CITY OF ALBUQUERQUE

**Re: Kidz Academy,
10751 Fineland Dr. NW, 87114
Request for Certificate of Occupancy
Transportation Development Final Inspection
Engineer's/Architect's Stamp dated 5-31-18 (A11D016)
Certification dated 1-18-19**

Based upon the information provided in your submittal received 1-29-19, Transportation Development cannot approve the release of Certificate of Occupancy for the above referenced project.

TRAFFIC CIRCULATION LAYOUT

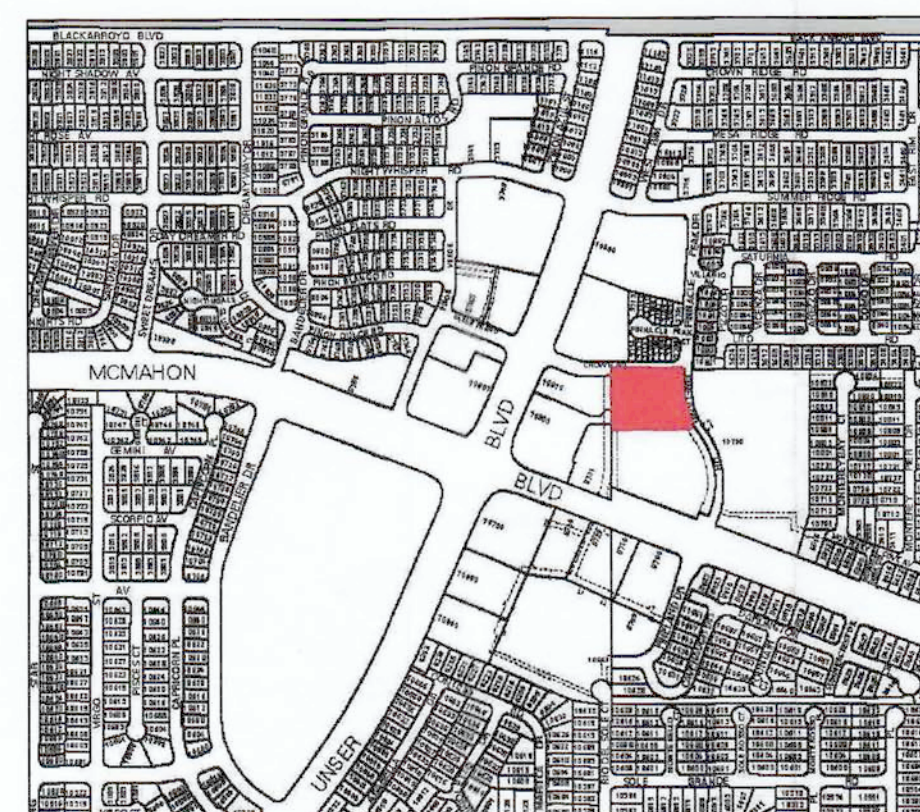
- Please submit an Administrative Amendment (AA) reflecting all changes to the approved DRB plan.
- The ADA accessible parking sign must have the required language per 66-7-352.4C NMSA 1978 **"Violators Are Subject to a Fine and/or Towing."**
- Per the IDO, a 6 ft. wide ADA accessible pedestrian pathway is required from the public sidewalk to the building entrances. (Walk path was relocated and width measurement was 4 foot, please correct.)
- Minimum width for parking stalls is 8 foot 6 inches. Please correct parking stalls at island with 8 stalls and 1 motorcycle parking. (Measurement taken at site, 8 foot)
